**Great North Road Solar and Biodiversity Park – Issue Specific Hearing 3 (ISH3)**

**Wednesday 4<sup>th</sup> February 2026**

Summary of Verbal Representations from Newark and Sherwood District Council (NSDC)

**Great North Road Solar and
Biodiversity Park
Environmental Statement**

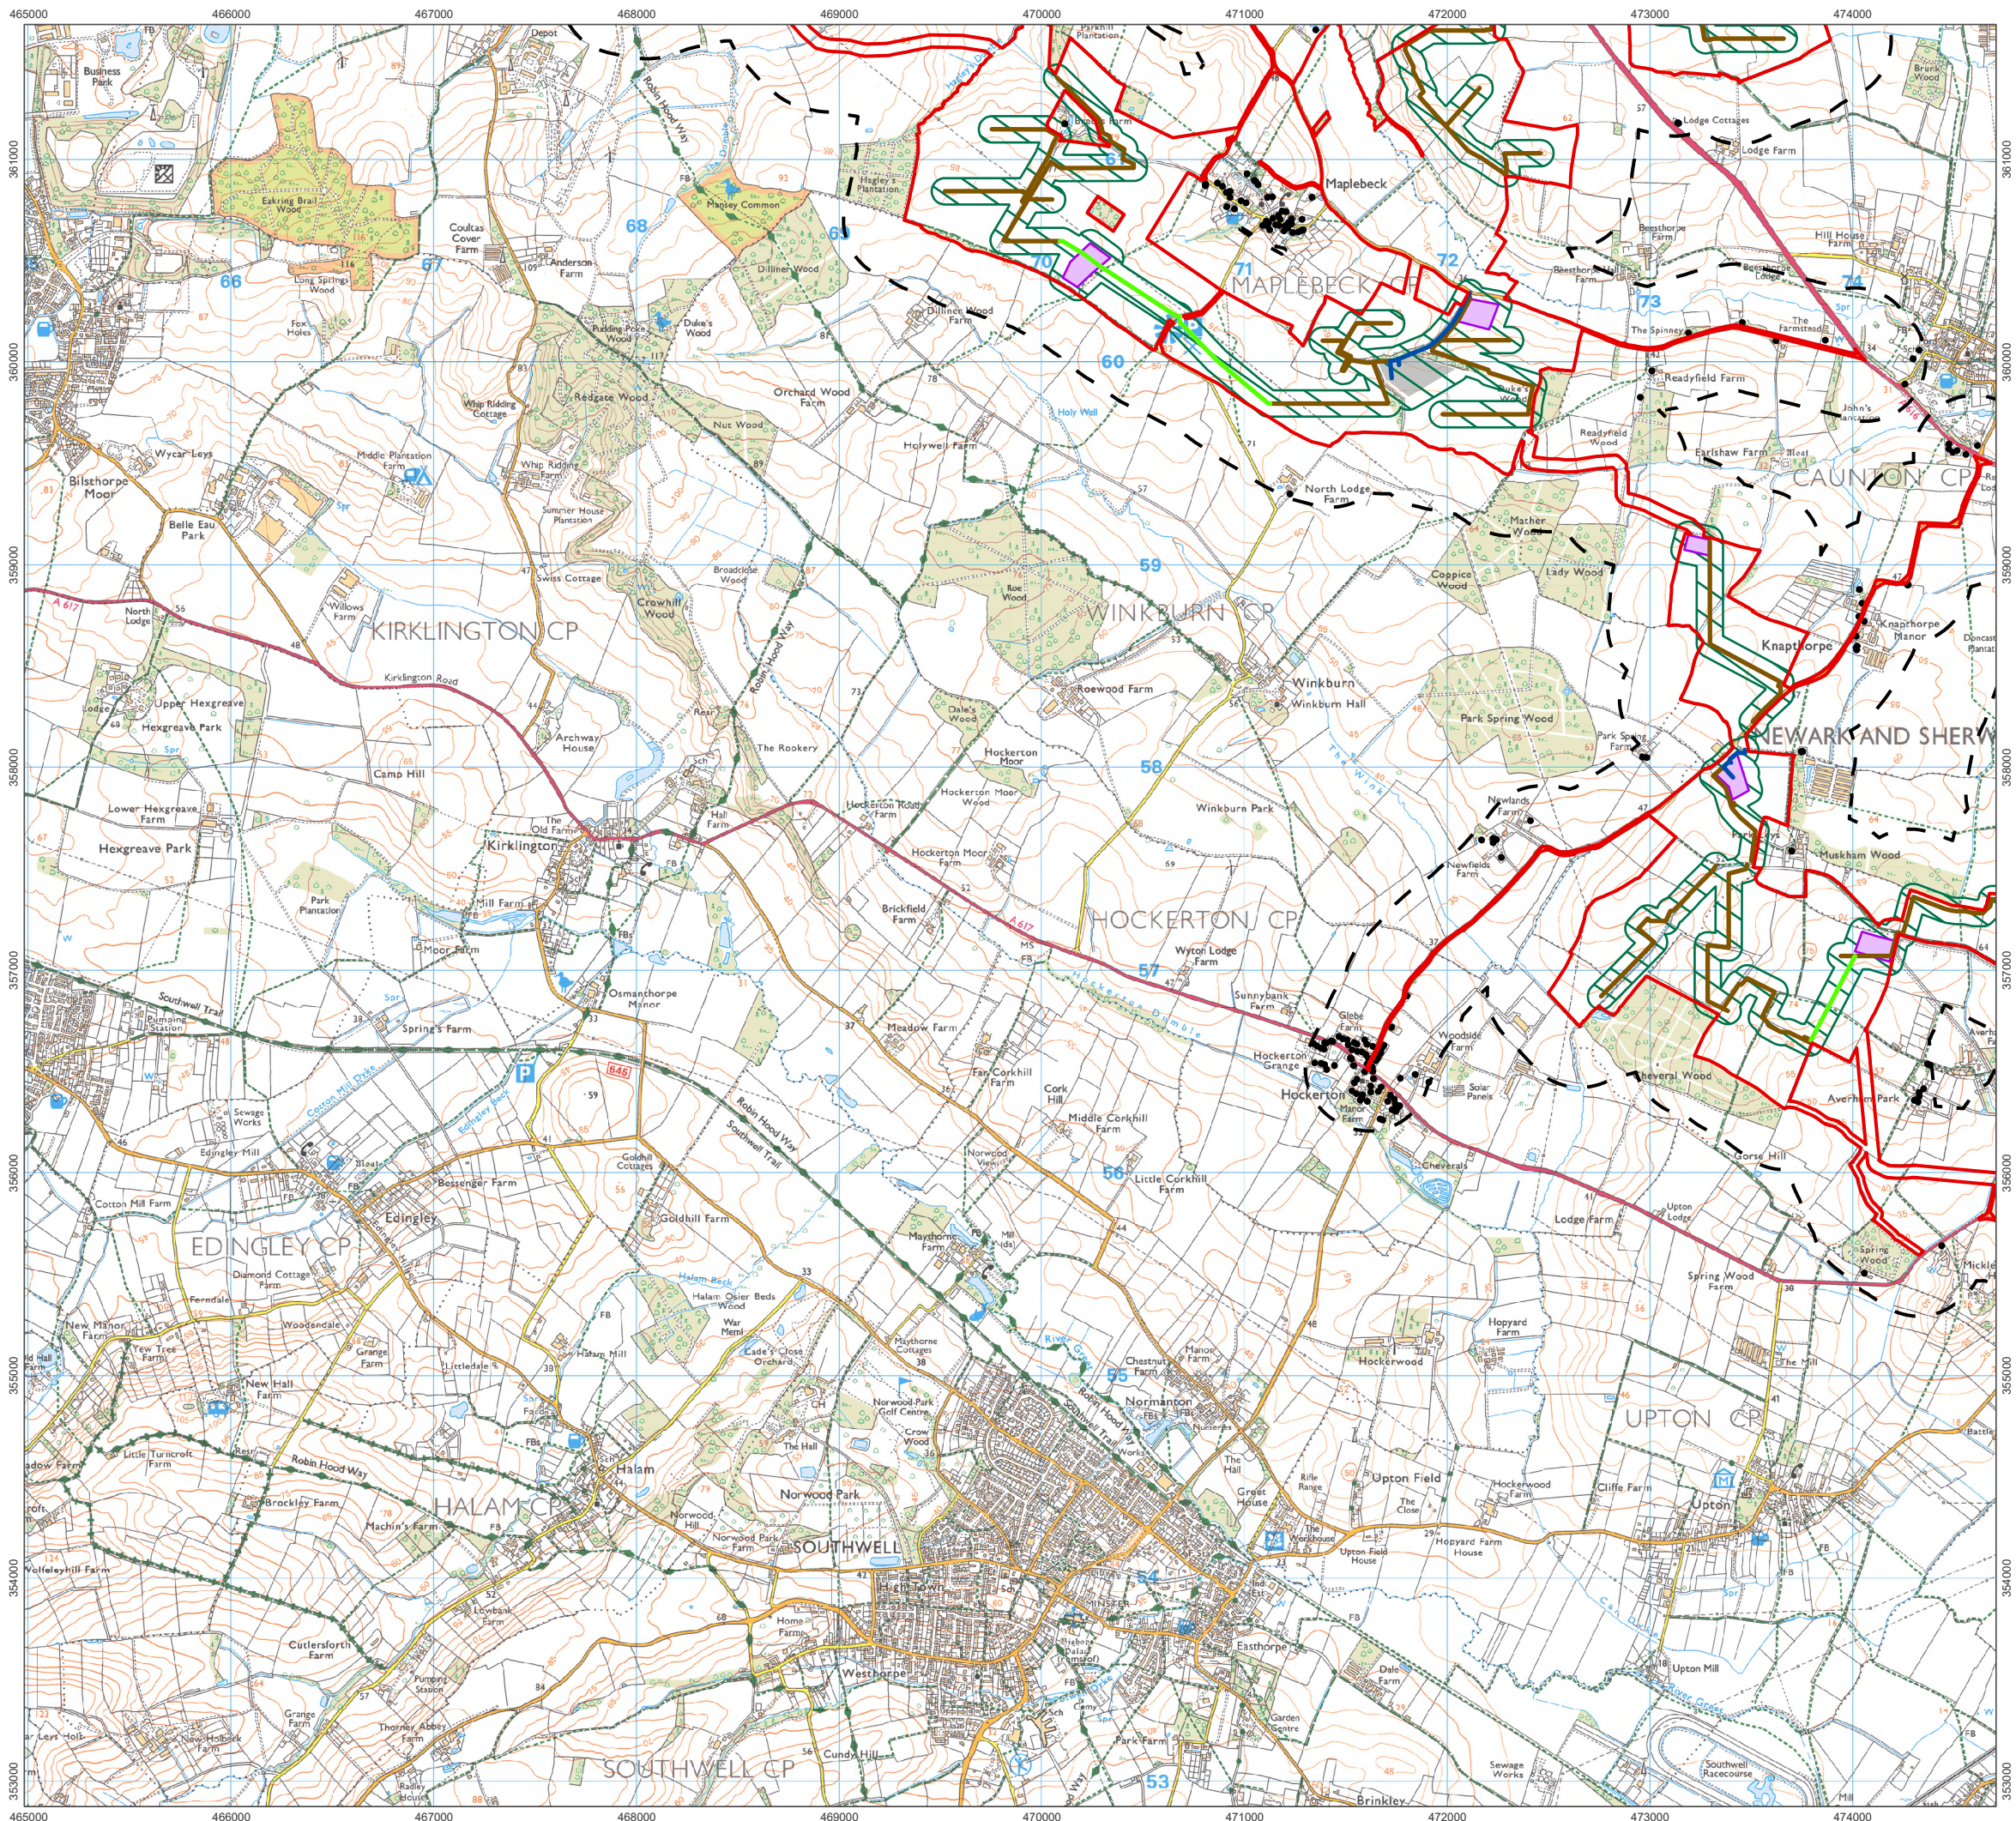
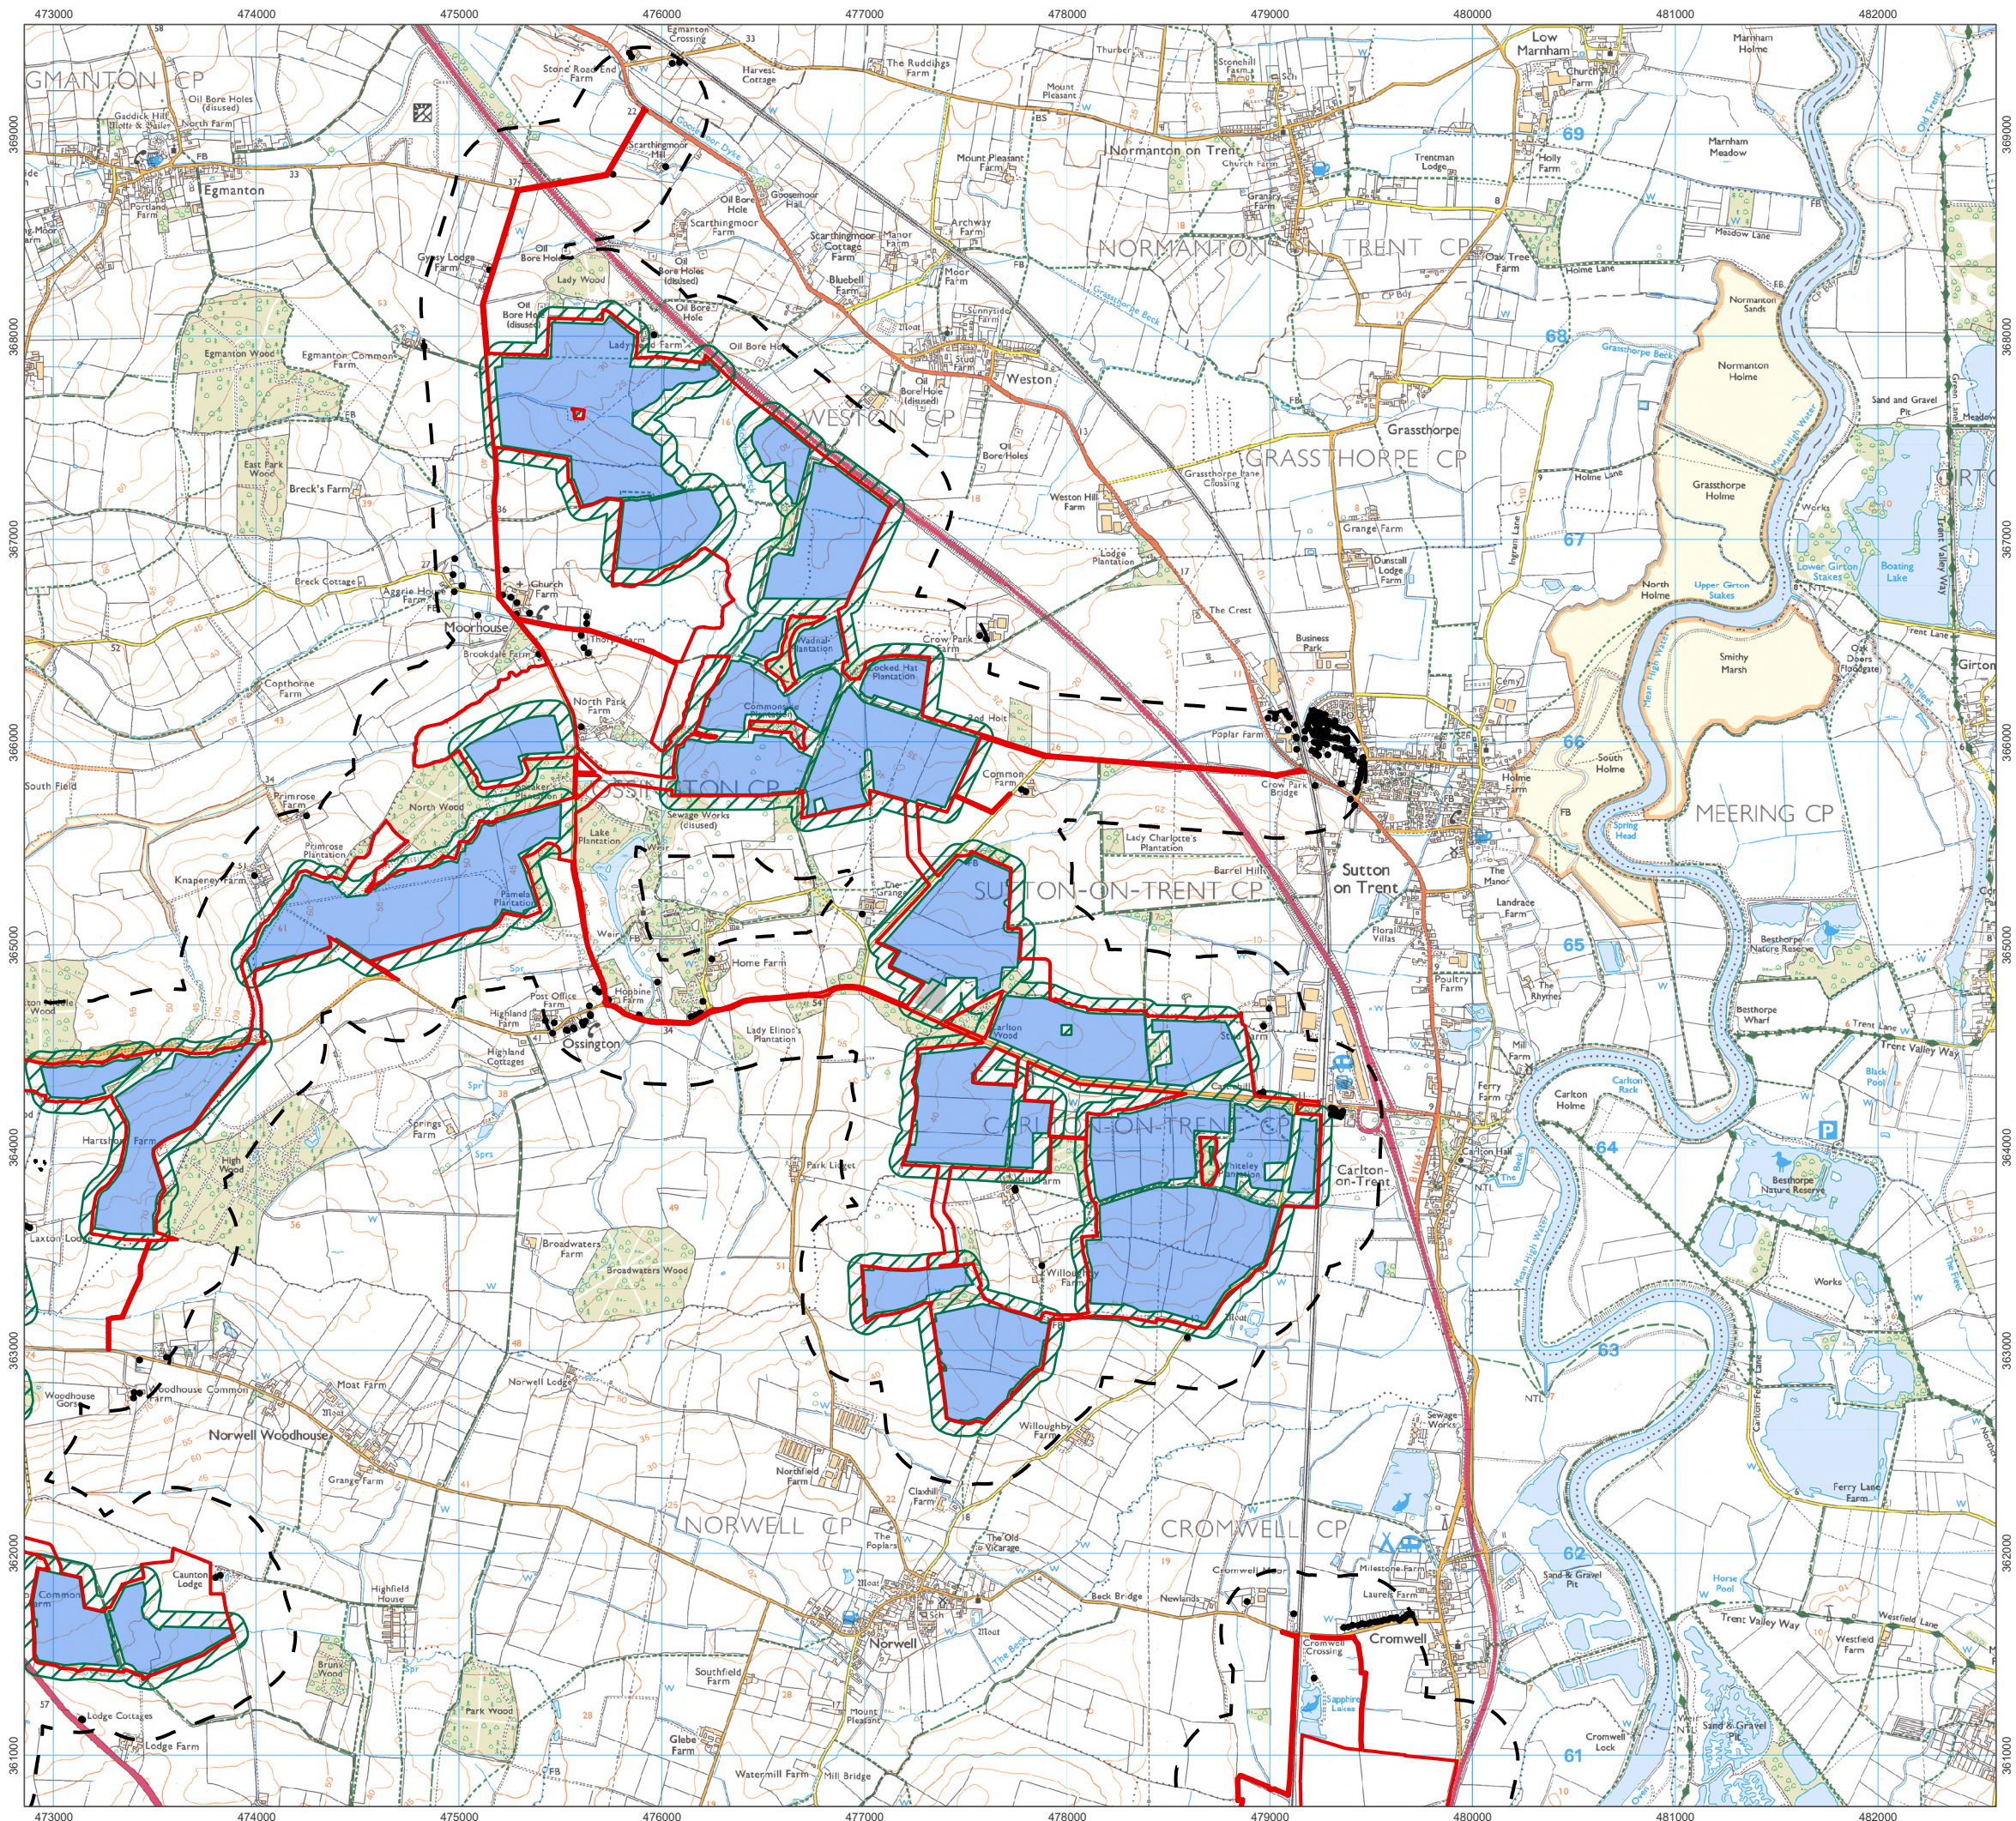
19. NSDC confirmed their opinion that the applicant has used appropriate thresholds for noise, derived from appropriate standards. Receptors have been identified within areas where noise levels are above the threshold, however the modelling assumes a 'worse case' with all noise sources operating continually and simultaneously, with no screening or other attenuation. Details of measures to control noise are to be provided through submission of a Construction Environment Management Plan (CEMP) and Noise Management Plan (NMP).
